Mallard Pass Solar Farm

Schedule of Changes Draft Development Consent Order

Deadline 5 (5th September 2023)

EN010127/APP/9.3.5

X:\LDA_4990\2002_MALLARD PASS SOLAR FARM\CAD\1.0_CURRENT\1.0.1_SHEETS\PROWS\4990-2001-T-067-078 + 090-091-P2 - TRAFFIC REGULATION MEASURES PLANS - TEMPORARY ROAD CLOSURES.DWG

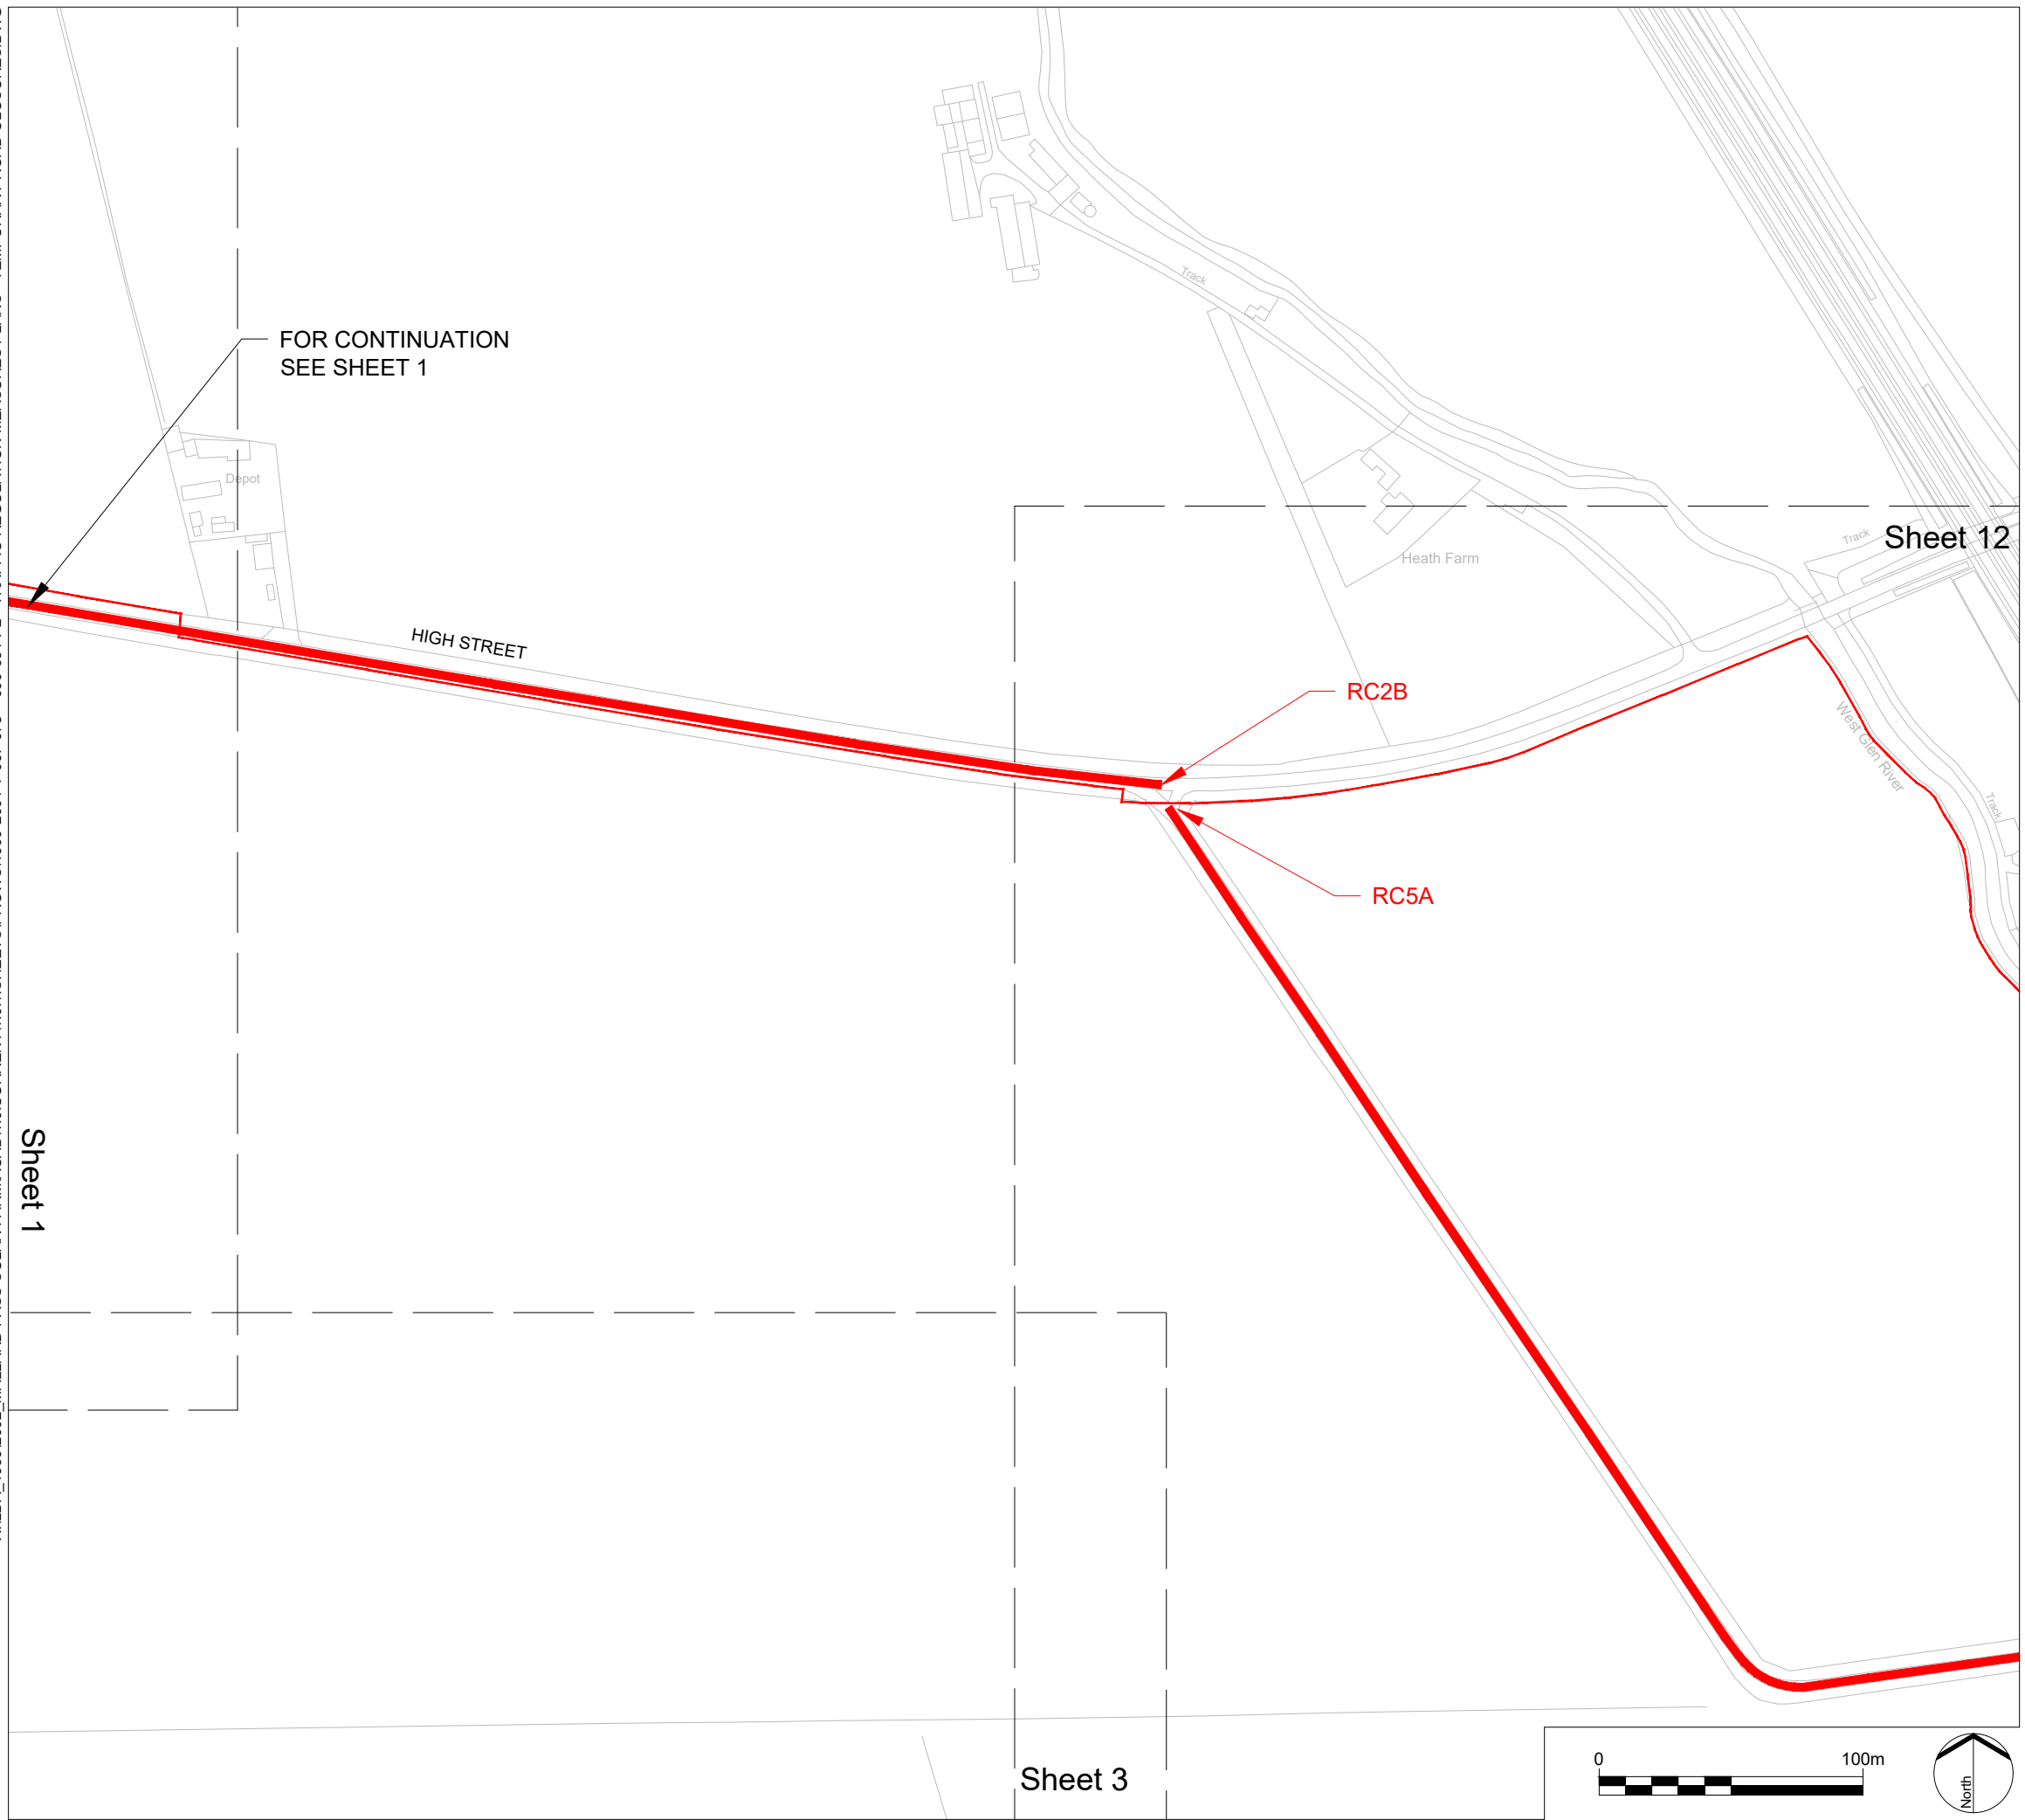
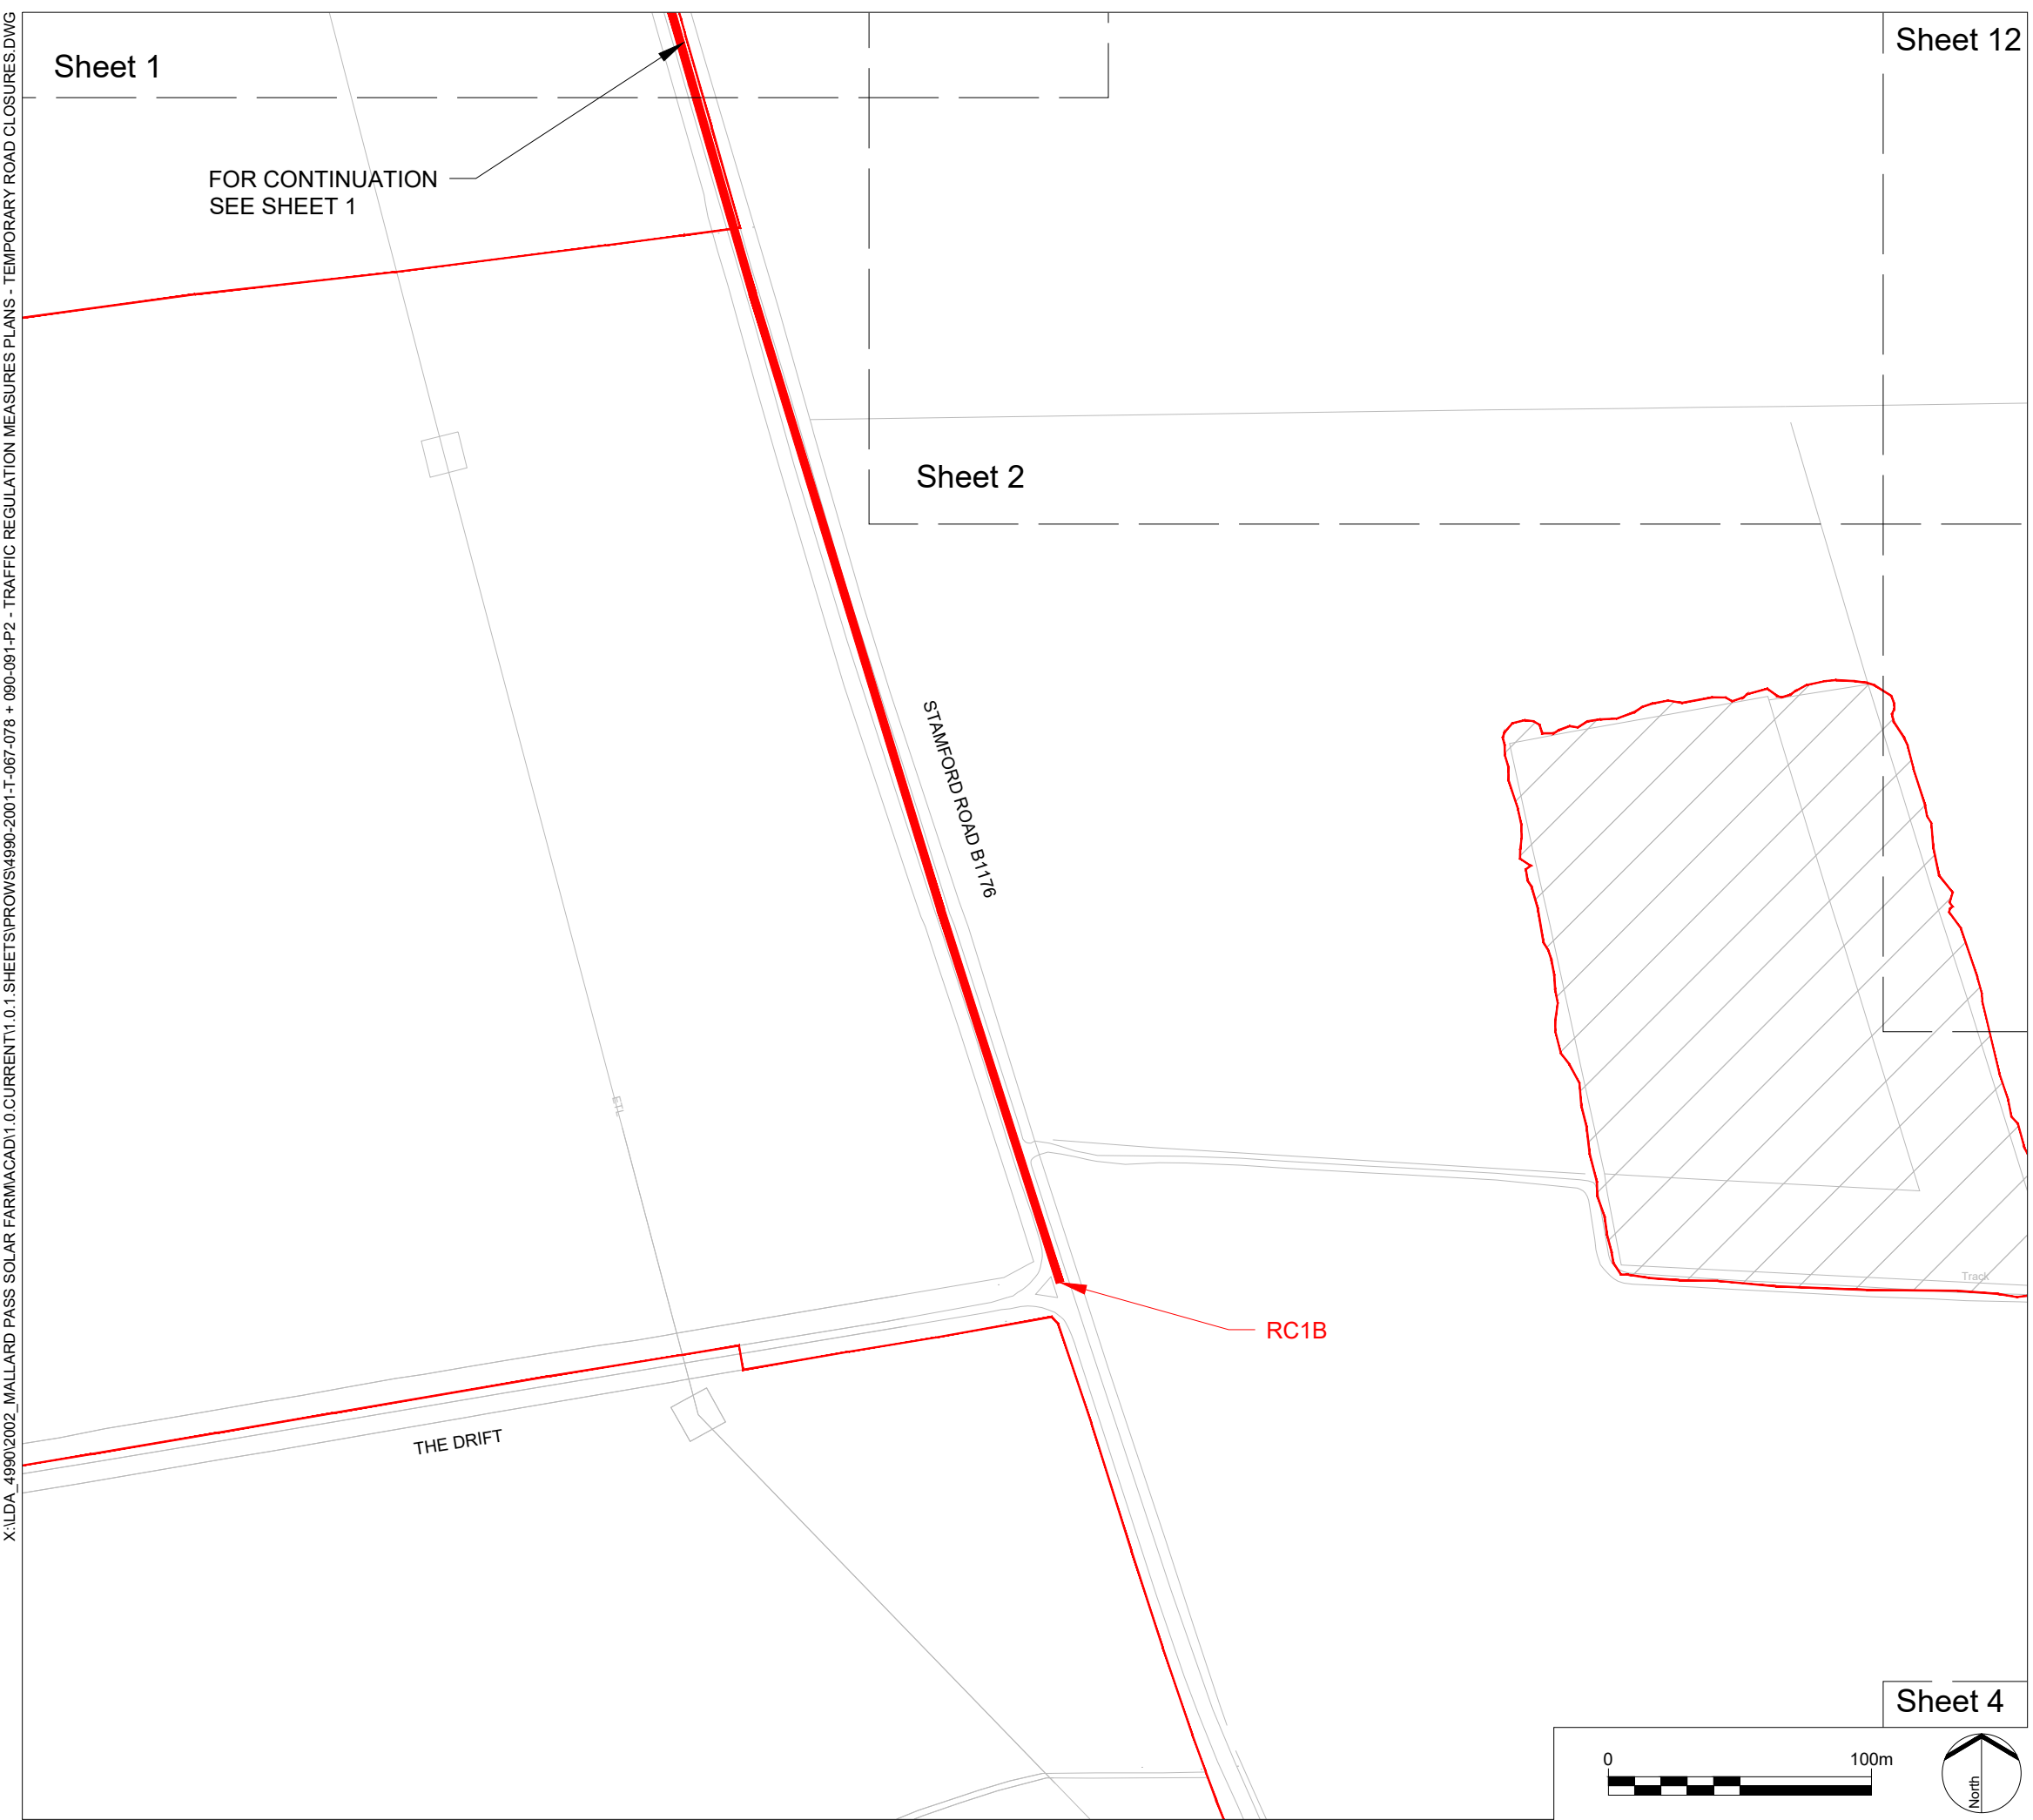
<p>draft Development Consent Order (Rev 0) to correct a typographical error.</p> <p>Other amends made to ensure Schedule is fully consistent with Access and Rights of Way Plans.</p>	
Schedule 8, Part 2	Insertion of an addition temporary road closure.	This has been inserted to reflect the updated traffic regulation measures plans – road closures (Rev 2) following comments made by MPAG at Deadline 4.	Deadline 5
Schedule 9	Amendment of definition of “vegetation maintenance rights” to include restricting or preventing the removal of vegetation.	Amended to provide further clarity on the extent of restrictive covenants sought (building on the similar drafting in the other 'categories' of rights in this Schedule) pursuant to article 22(2) following the ExA's Second Written Question 5.0.6.	Deadline 5
Schedule 4, 5, 6, 7, 8	Amendment from 'District' to 'Area'	Amended following the ExA's Second Written Question 5.3.1	Deadline 5
